09634
16 May 2012

**MODIFICATION TO MAJOR PROJECT (MP10_0189)
STAGE 1 PHASE 1 FRASERS PUTNEY, SYDNEY**

On behalf of Frasers Putney Pty Ltd, we write to request the Minister (or his delegate) modify the Project Approval 10_0189 under Section 75W and Clauses 2(1)(a) and 3(1) of Schedule 6A of the *Environmental Planning and Assessment Act 1979* (EP&A Act) as described below. The proposed modification relates to the removal of Condition D3 (Assessment by Sydney Water Geologist) and changes to the approved apartment building including:

| Drawing Title     |          |            |  |
|-------------------|----------|------------|--|
| STREET ELEVATIONS |          |            |  |

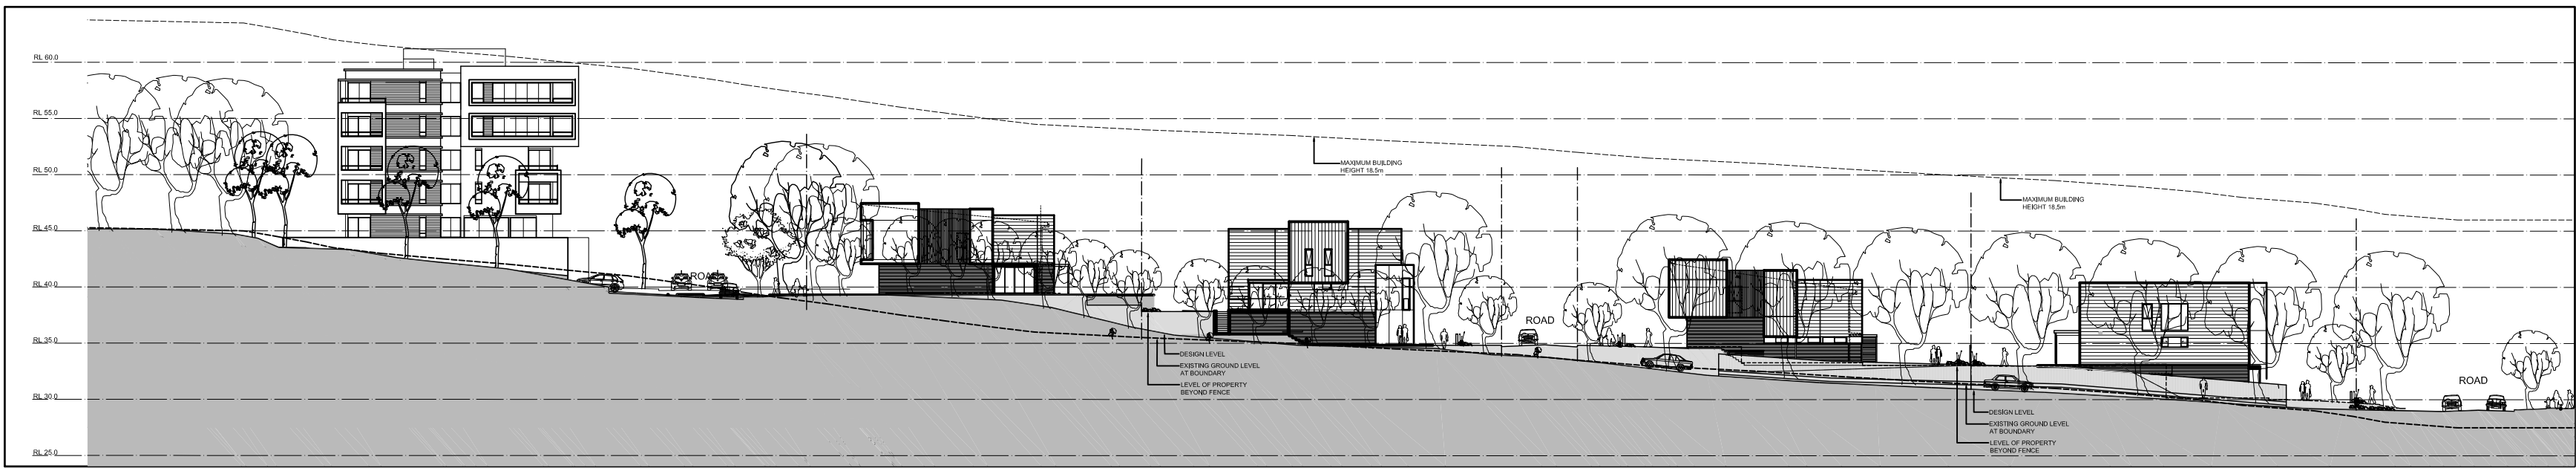
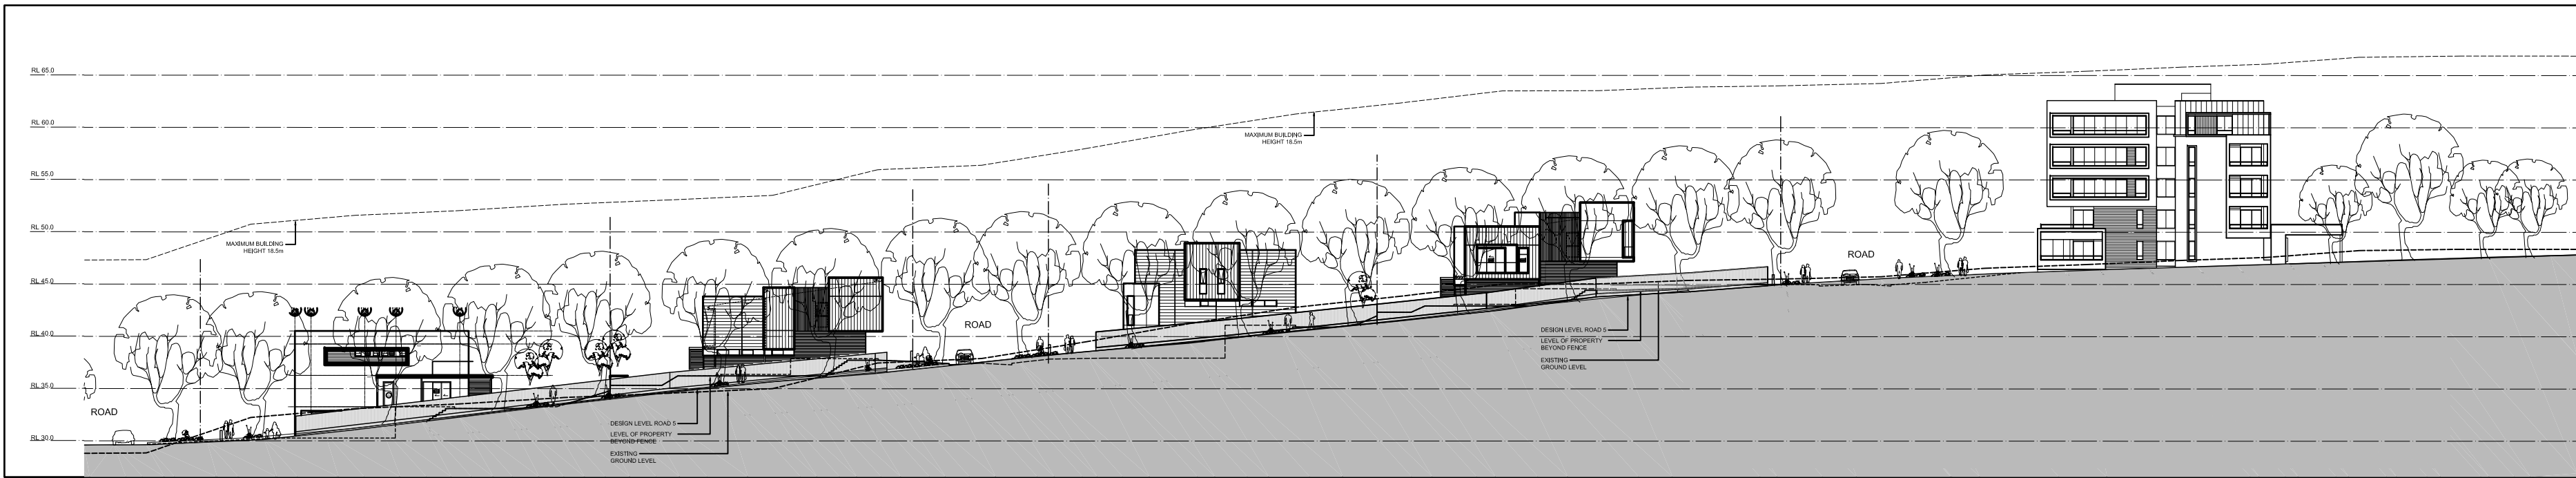
The maximum height of the building has been increased from RL64.0 to RL64.25 as a result of the building being slightly lifted. There has also been an increase in the parapet height of 0.35 metres RL61.85. An overall increase of approximately 585.5m² in the GFA of the apartment building is proposed.

The adjustment of the upper level setbacks has enabled a better corner articulation at the street intersection of Road 5 and Road 16. The reconfigured floor plates have led to the repositioning of balconies on the northern and southern façades. The design of these balconies will be similar to the approved building in that they will create an interesting and articulated built form. **Figure 1** and **Figure 2** illustrate the proposed modifications to the apartment building.

| Drawing Title<br>APARTMENT PLANS                            |                   |                    |           |

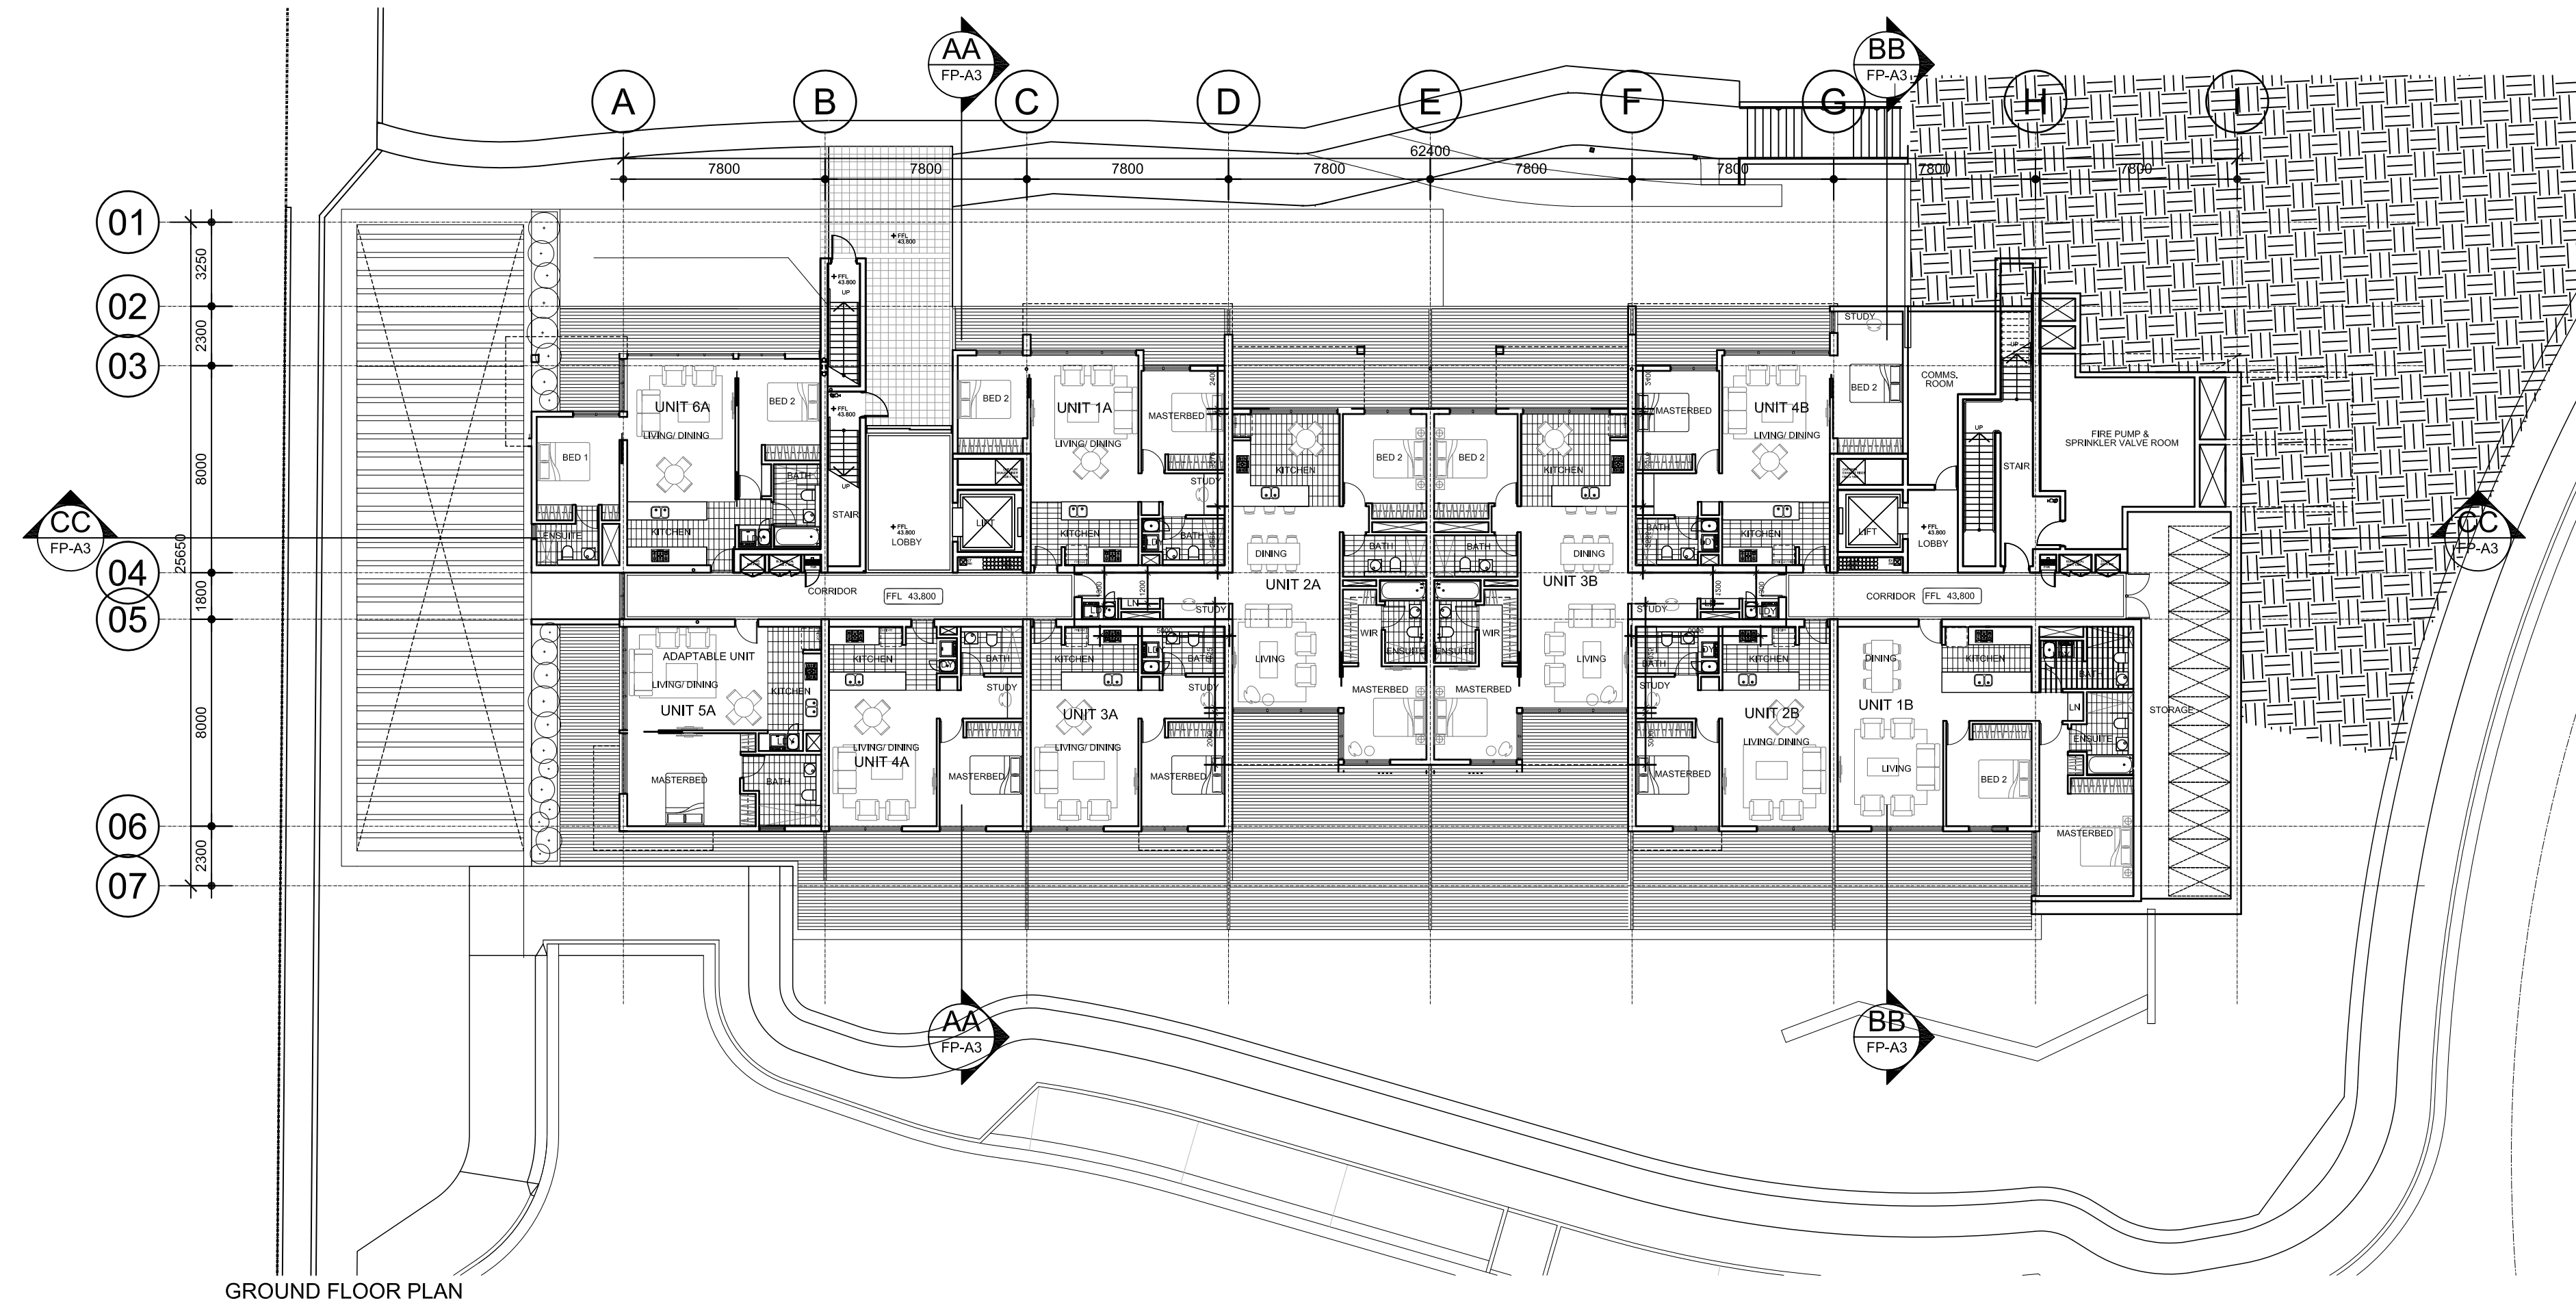
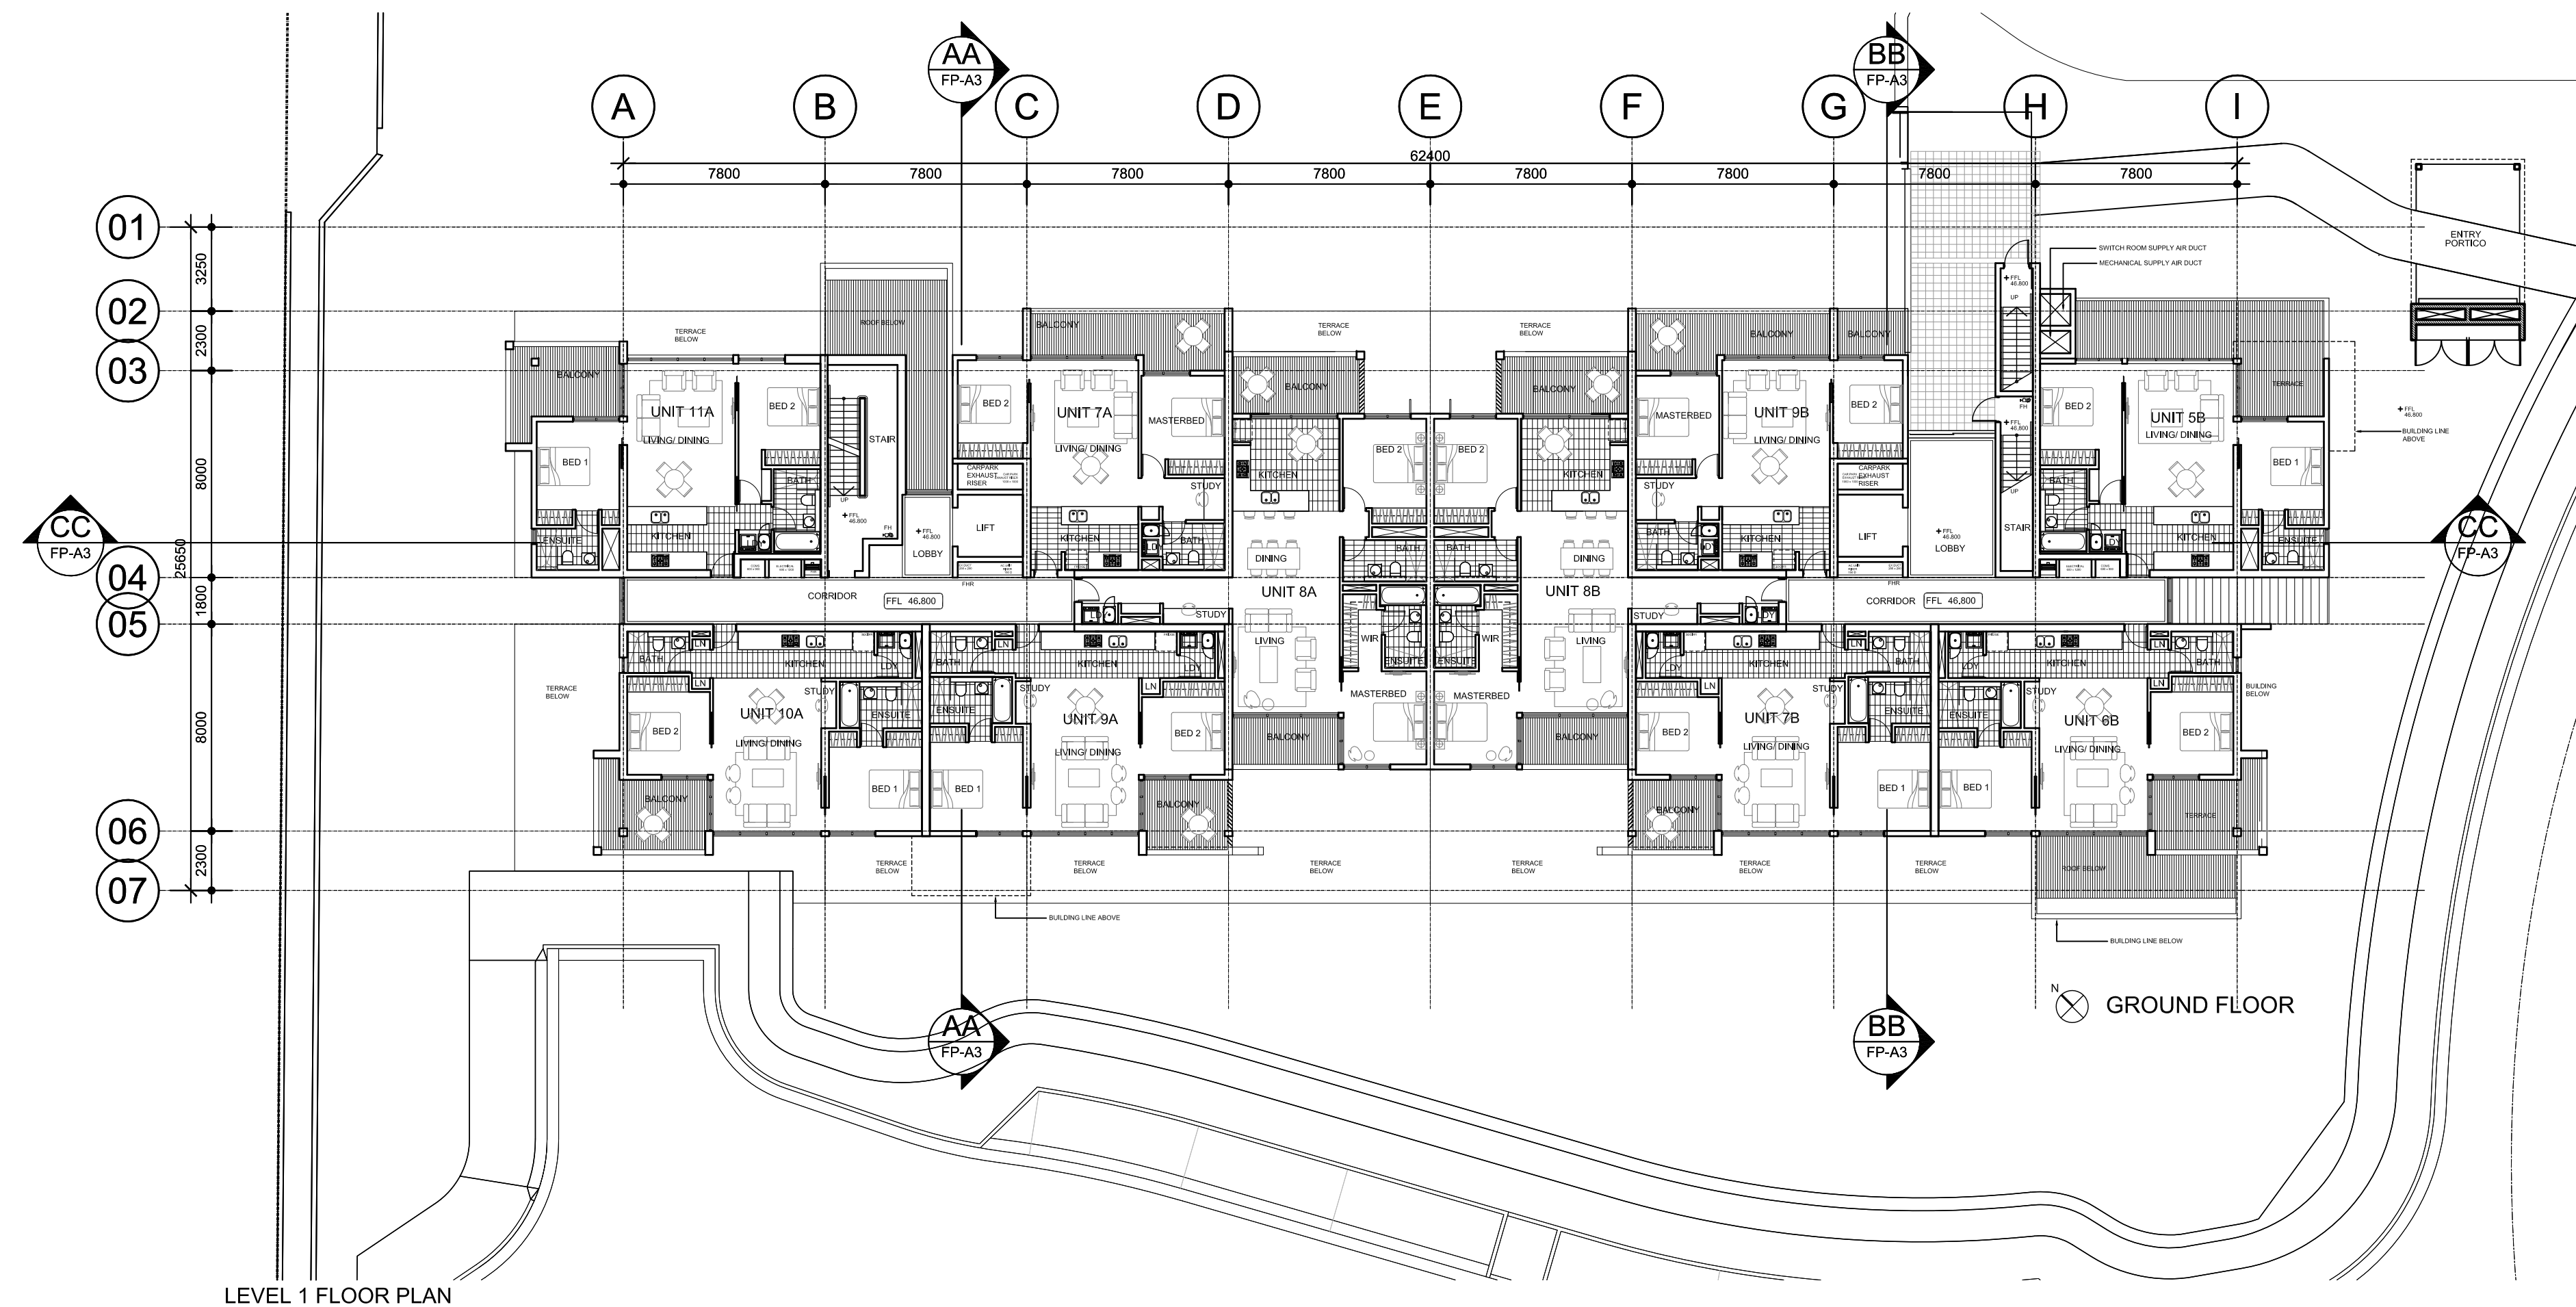
The proposed modifications involve a minor amendment to the siting of the building due to the repositioning of balconies across all levels. An adjustment to the upper level setbacks currently approved for levels 3 and 4 are proposed to accommodate the additional apartments.

It is proposed to reconfigure the approved floor plates within the apartment building. With these reconfigured floor plates there has been an addition of seven apartments. The proposed dwelling mix has been revised as a result of these design amendments and additional apartments. **Table 1** provides a numerical overview of the proposed changes.
